18th December 2015

The Secretary
NSW Department of Planning and Environment
GPO Box 39
Sydney NSW 2001

State Significant Development Application and Variation of the Sydney Cove Redevelopment Scheme for the “*Remediation, Renewal and Adaptive Re-Use of Campbell's Stores*”, The Rocks (SSD 7056)

DIAGRAM: Proposed Massing

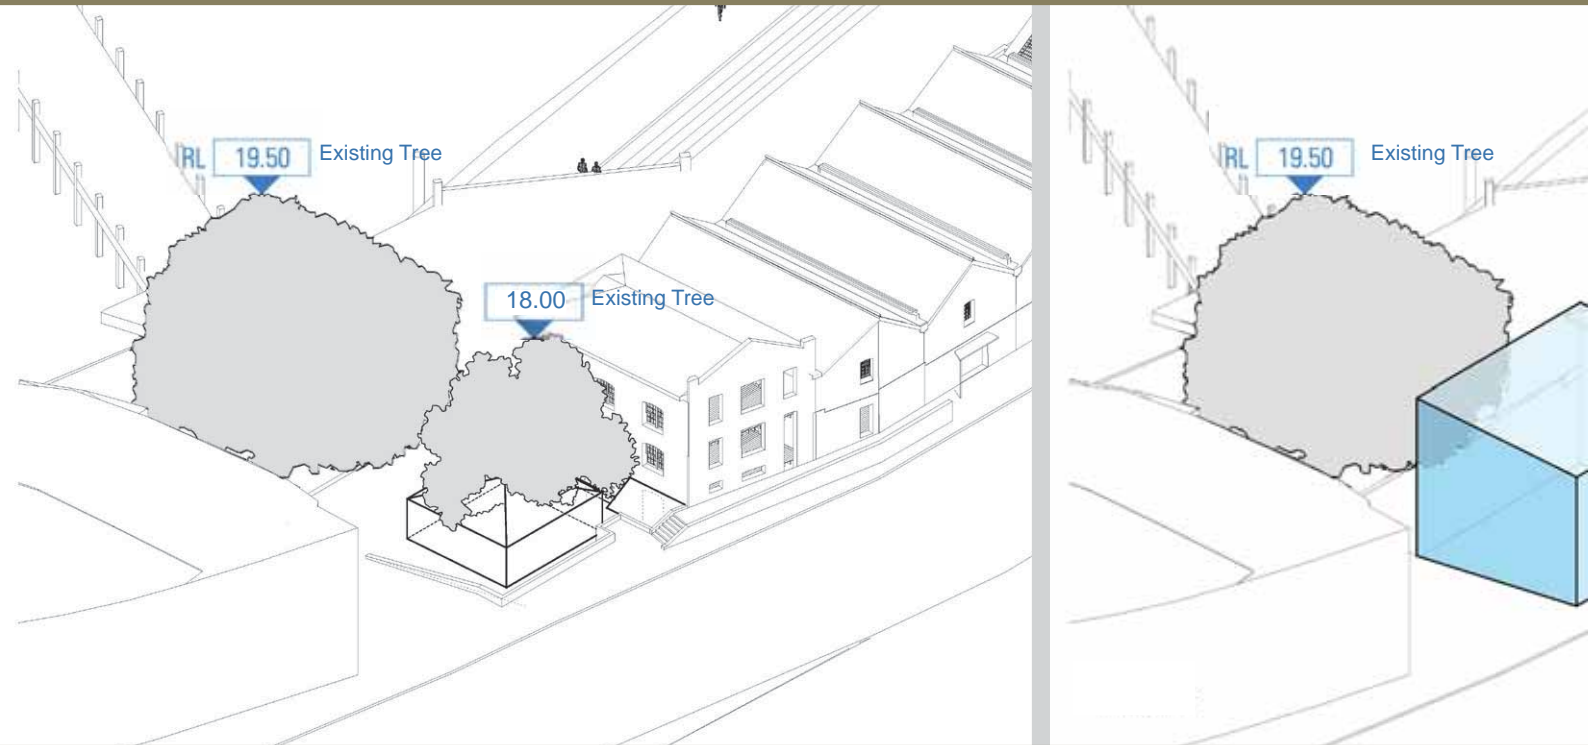
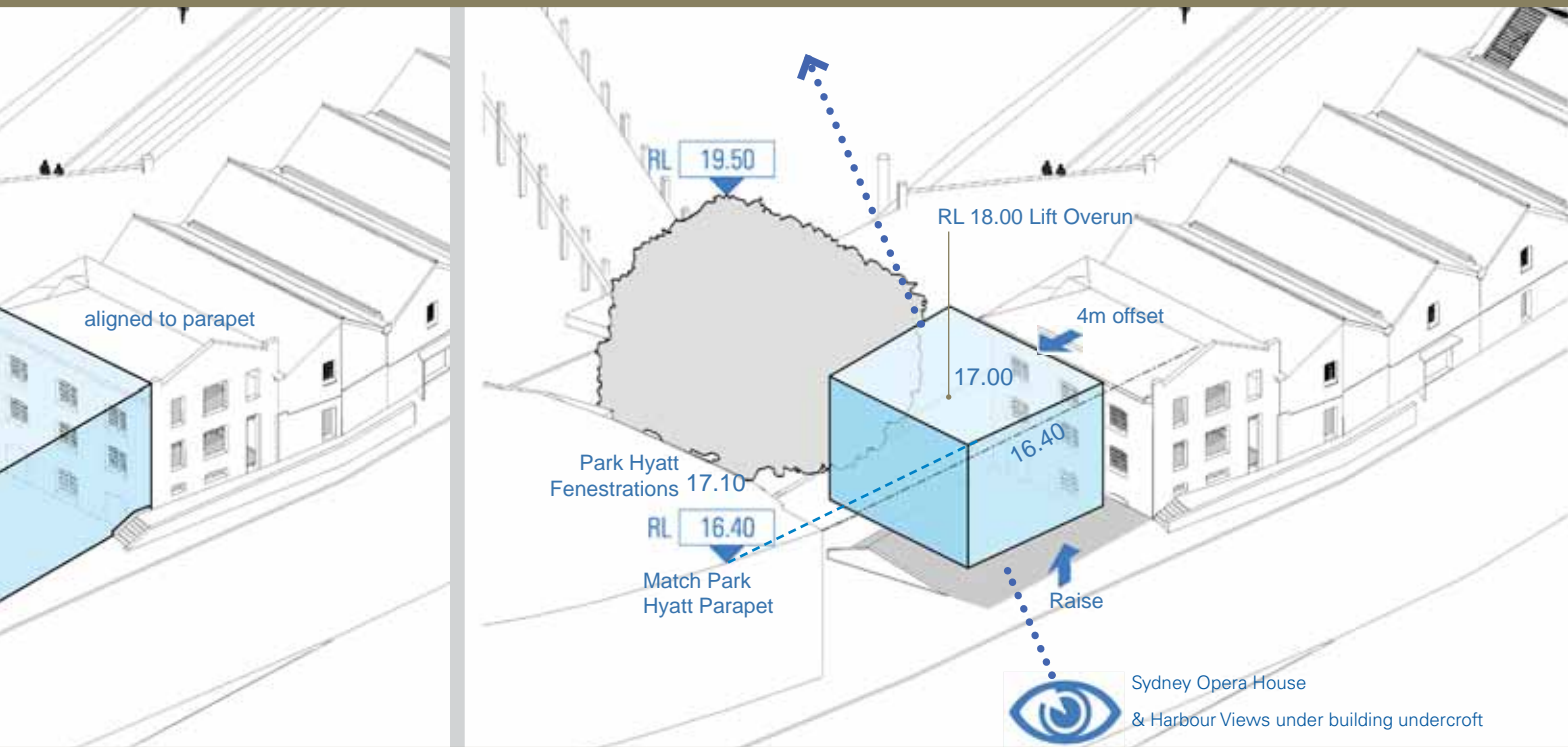
- Campbell's Stores has been a stand-alone building for most of its life and certainly since about 1902. Prior to that only minor structures and a single storey cottage were within the area to the north of Bay 11. The Stores have never been seen as part of a continuous street façade of mixed architectural styles (as the applicant has recently claimed). Rather, the Stores were for most of their existence 19th century waterfront warehouse buildings, of simple utilitarian design, viewed in the whole. To 'fill the gap' between the Stores and the Park Hyatt and treat this part of the site as an 'infill site' as the

architects have recently described it, is to irrevocably and detrimentally alter the heritage setting of the Stores and the historical context within which it will be appreciated.

HICKSON ROAD ELEVATION (NTS)

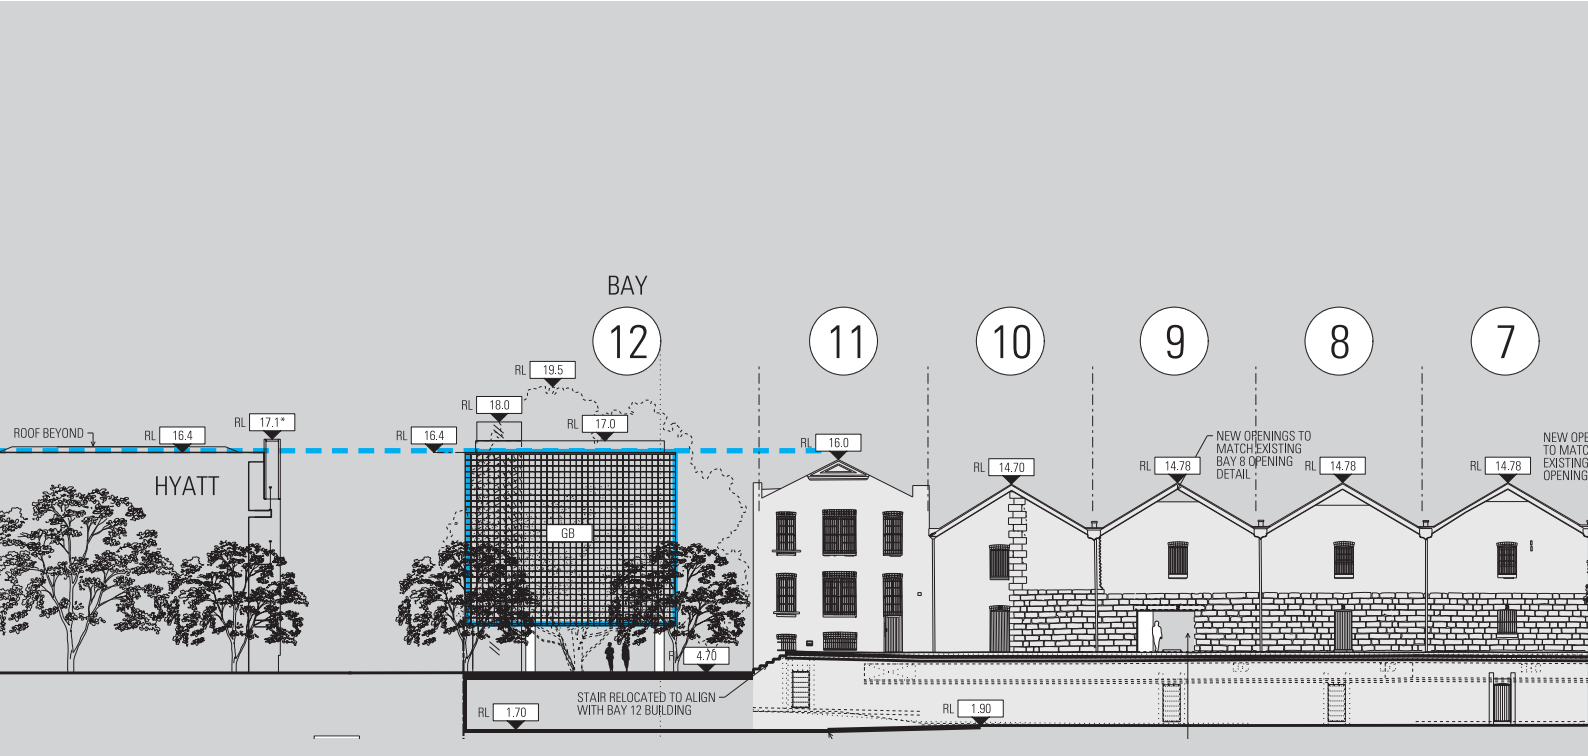
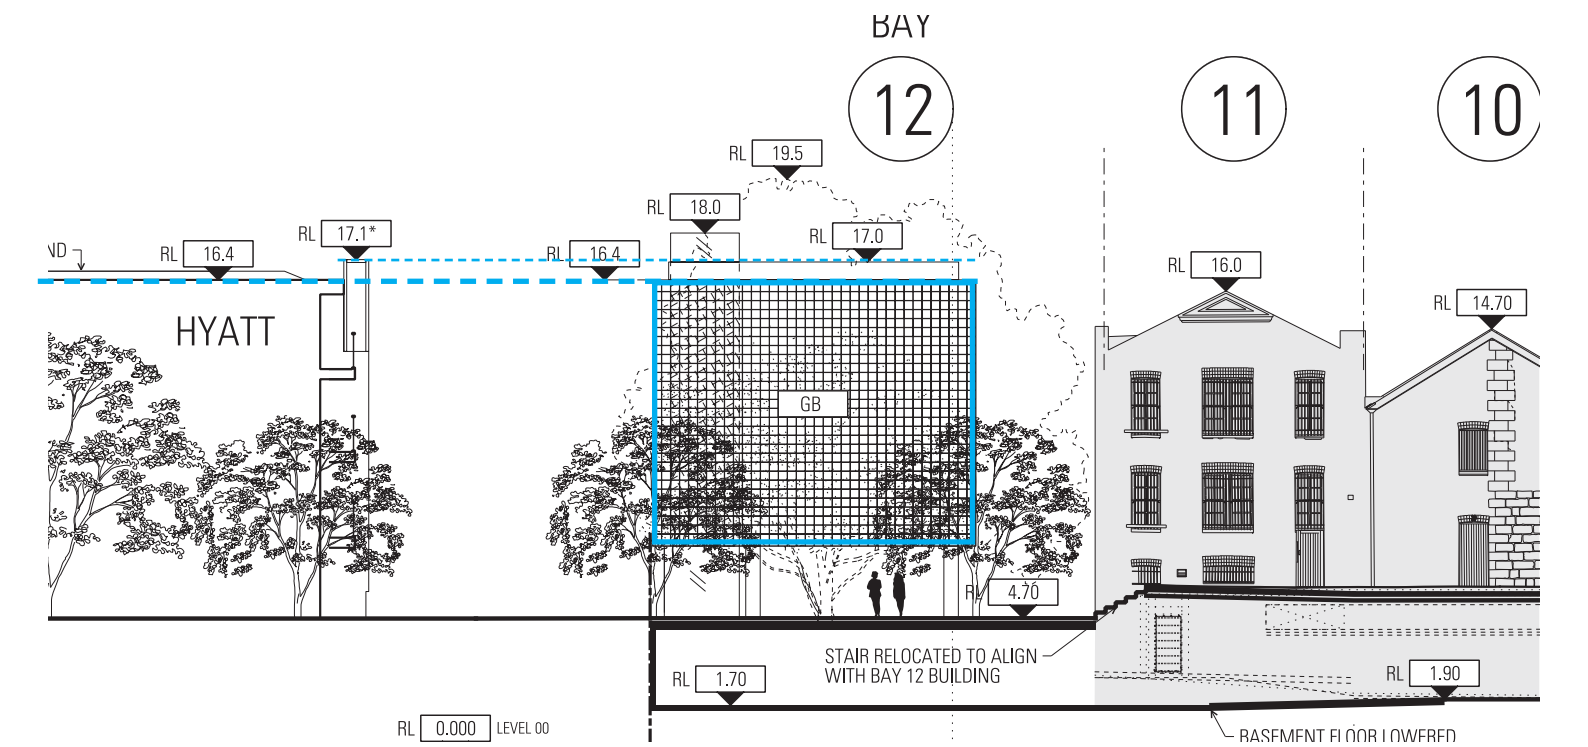
- The proposed glass box would be located next to Bay 11 on the northern elevation of Campbell's Stores. When measured from the proposed new ground level, it would be 13.3 metres high with the inclusion of its 1 metre high lift overrun. This exceeds the height restriction on the foreshore frontage by 14.5m, more than 250% and on the Hickson Road elevation by 10.5m, or 140%. **This would require a significant spot re-zoning under the Sydney Cove Re-Development Authority Scheme (SCRAS). One-off variations to this should not be permitted in advance of the Premier's holistic review of planning for the Sydney harbour foreshore.**

- Given this height and bulk, the proposed new four-storey glass box would dwarf the heritage-listed Stores, dominate the Campbell's Cove foreshore and be the tallest building on this section of the Hickson Rd streetscape.

Another typical example of the apparent deception is the diagram on page 96 of the Design Statement shows that the glass box would be one full storey higher than the gutter level of Campbell's Stores and then there'd be the lift overrun on top of that! There's a lot of detail and information conveniently included in those diagrams that is not evident elsewhere.
